### **RE: Black Horse Sign Permit (SI-21-00003) - Deemed Incomplete**

Community Development Services (CDS) received your application for a sign permit at Black Horse Development on parcel 431033 on December 8, 2021.

FRONT ELEVATION
SCALE 1/2" = 1'-0"

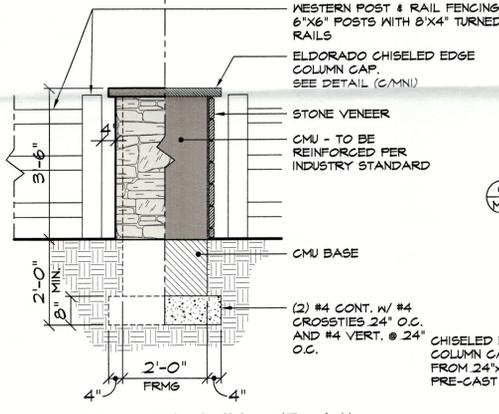
Upon preliminary review, the proposed monument sign does not meet specific provisions in the sign code seen in Kittitas County Code (KCC) 17.70. After reviewing previous documents for the approved landscaping plan that showed a monument sign but did not include dimensions to scale, it makes KCC Chapter 17.70 Signs the default sign standards for this project. The proposed monument sign does not meet the standards given in KCC 17.70.070(1)(a) or KCC 17.17.070(1)(b). Under KCC 17.170.070(1)(a), "*monument signs shall be no larger than thirty-two (32) square feet*". The proposed sign face of the monument sign is approximately 69 square feet. KCC 17.70.070(1)(b) states that monument signs are limited to "*no taller than seventy-two (72) inches above the finished grade when located outside of the sight triangle*". The proposed monument sign is eighty-four (84) inches above the finished grade. In order to keep processing, the monument sign must be redesigned to meet these provisions of Kittitas County Code. The other options besides redesigning to keep the proposed sign would be the following:
